Response to Comments, May 17 Email

Response to Comments, May 23 Email

1 FIRE DOOR A44 POCKET AND STRICKER PLAN DETAIL

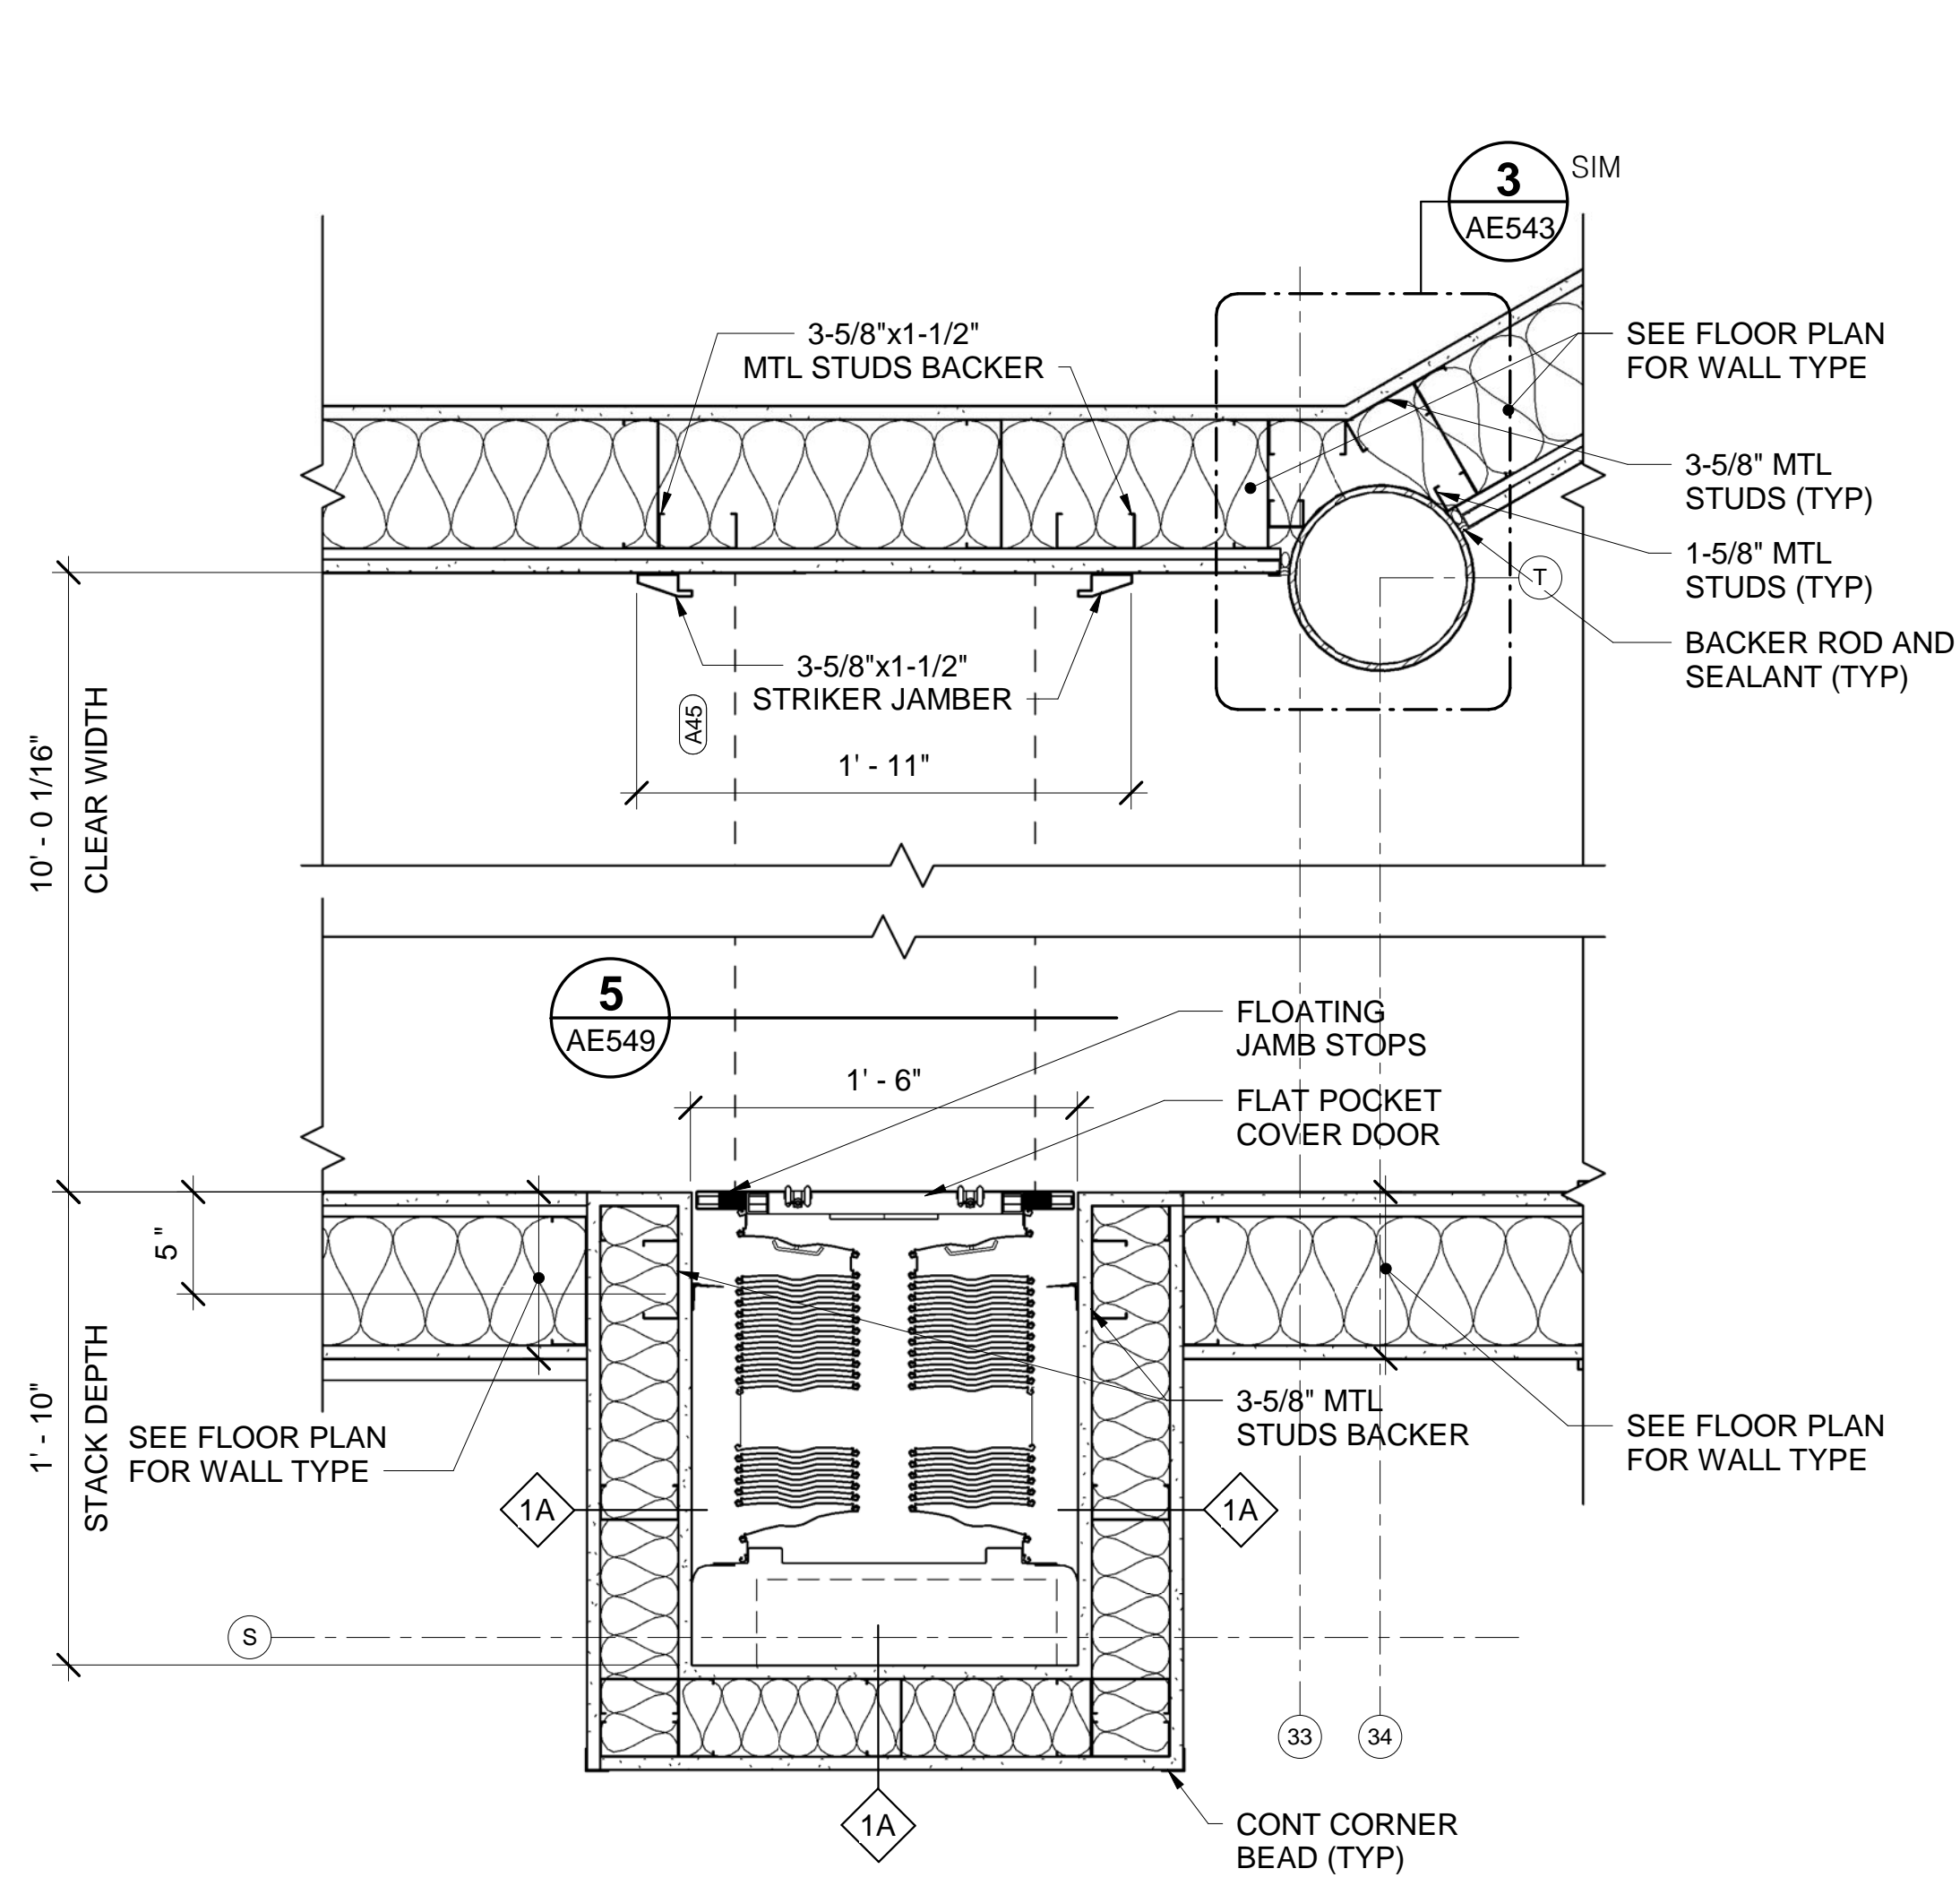
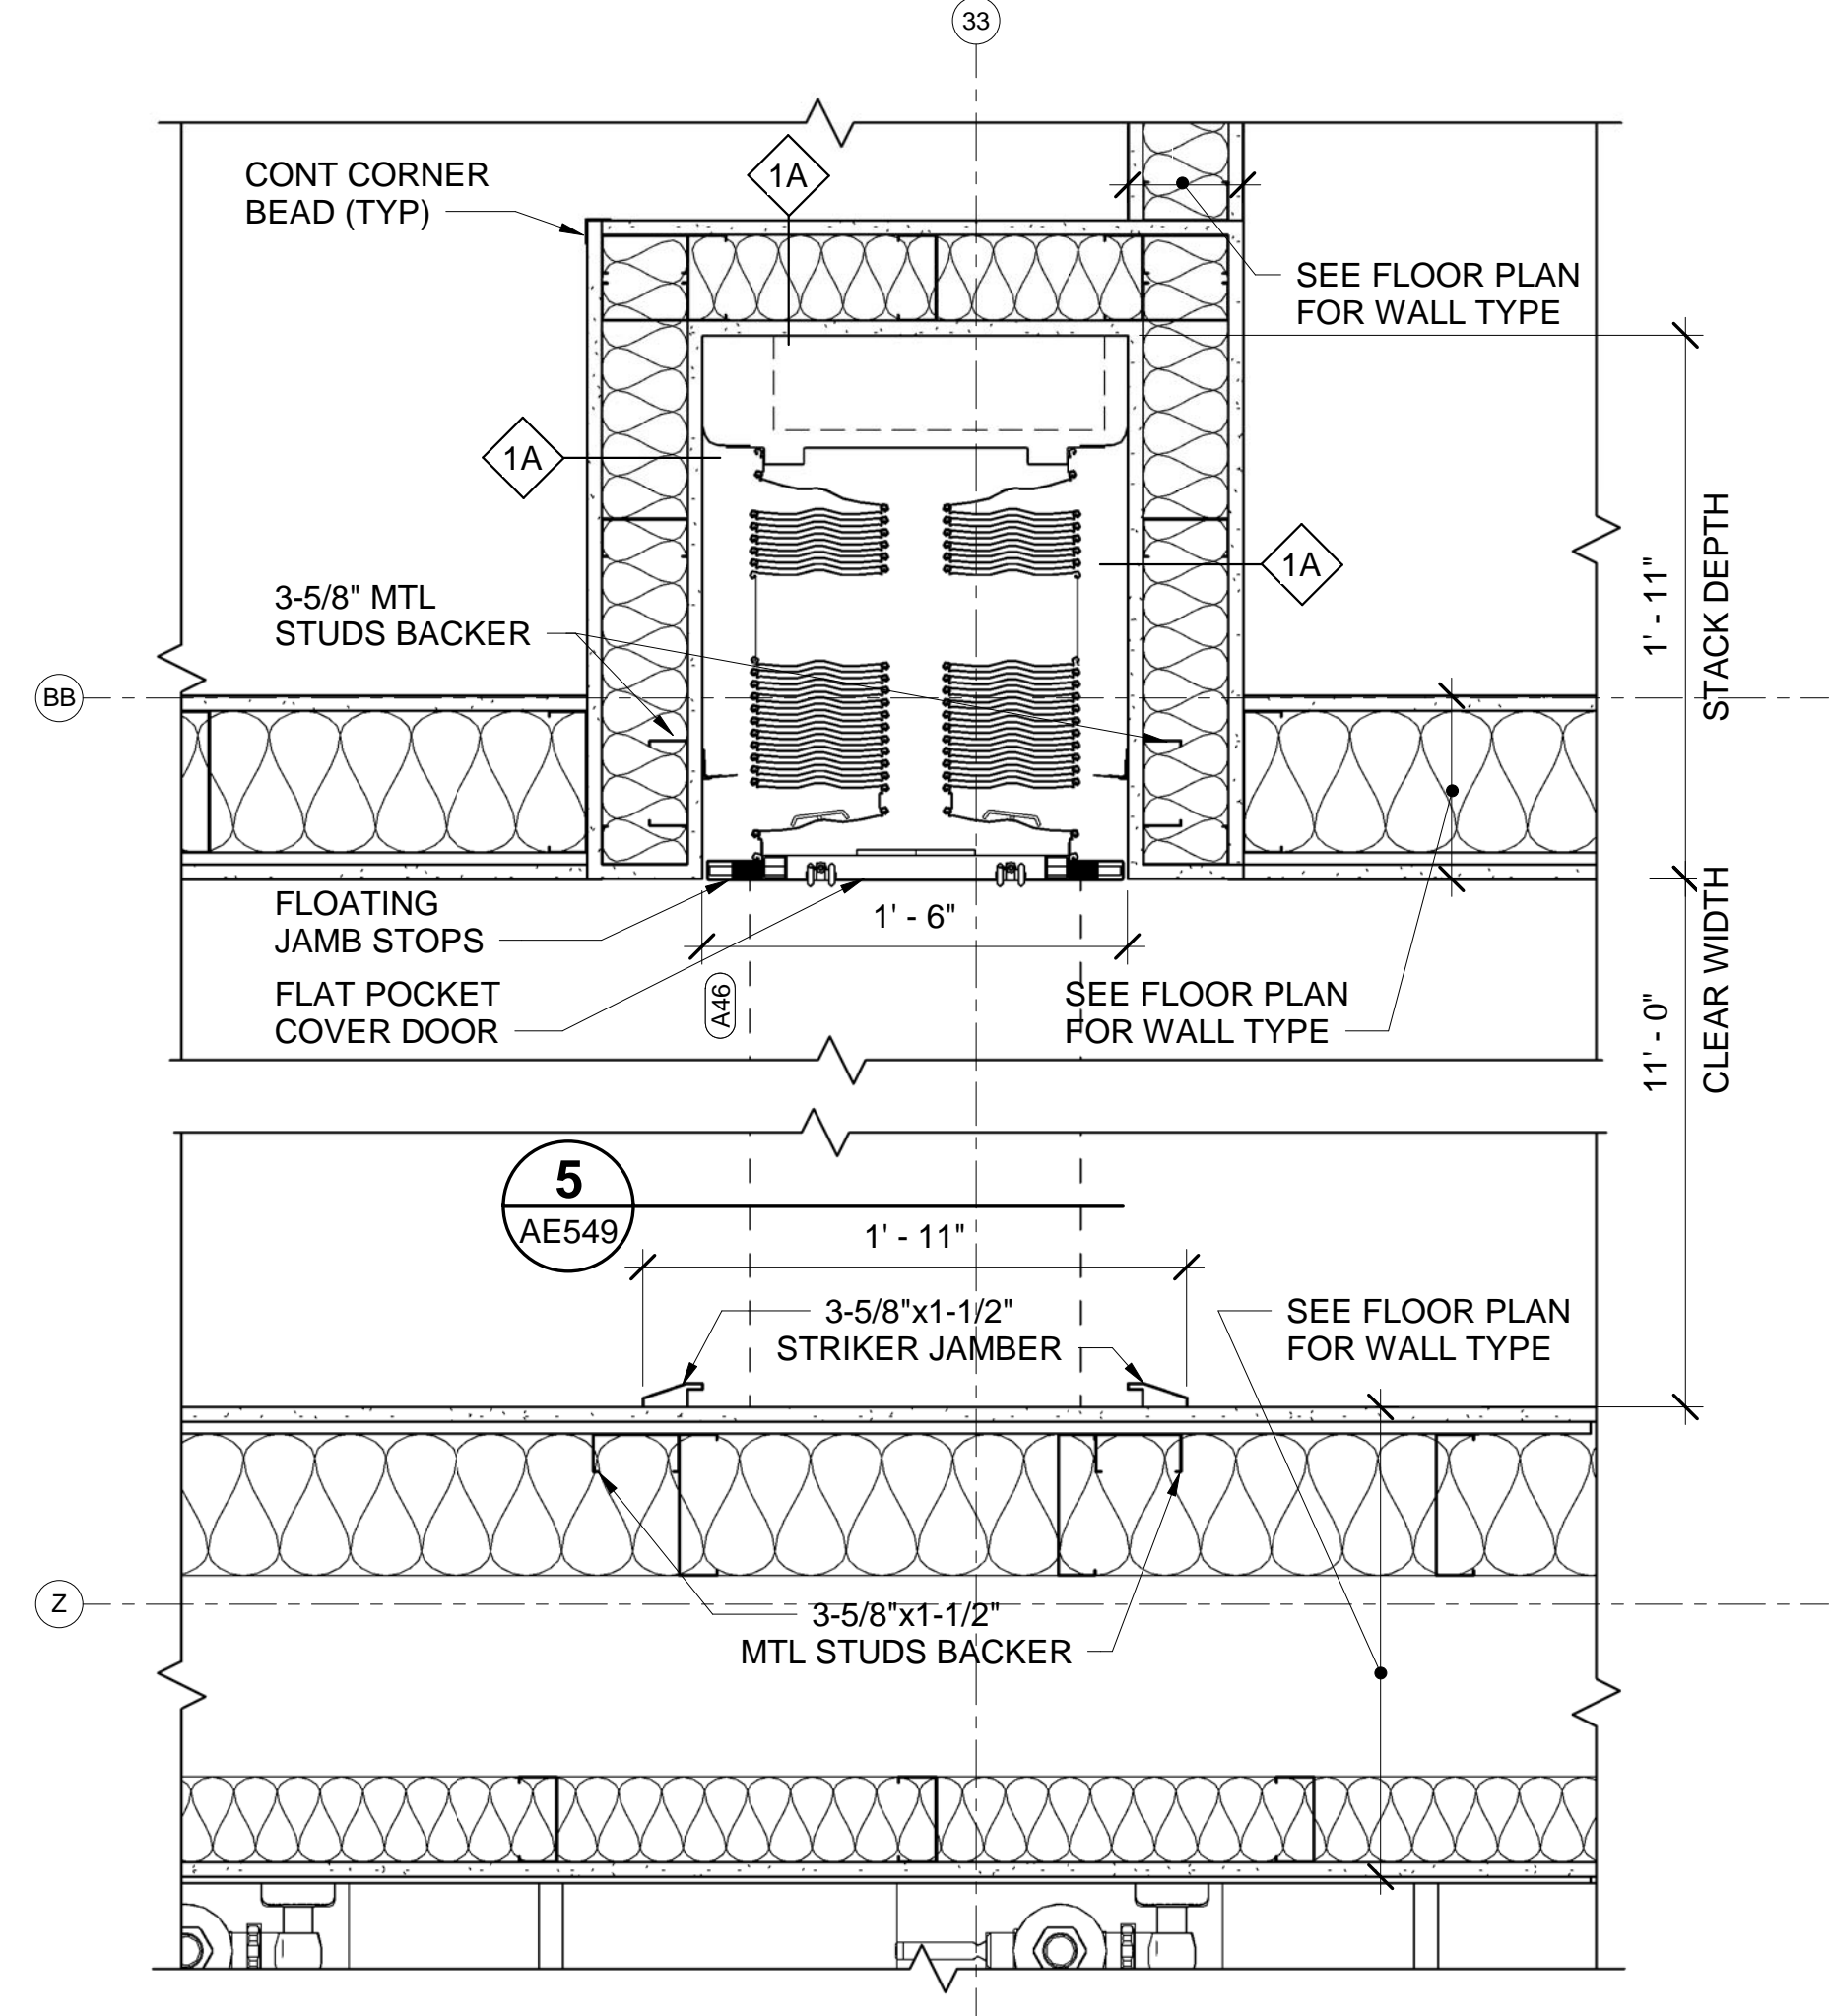
Q: I see that the two lobby areas are shown as fire walls. I do not see where the details are for the extension of these fire walls are called off. Please clarify the intent.

A: Fire wall details are located on sheets AE547, AE548 and AE549.
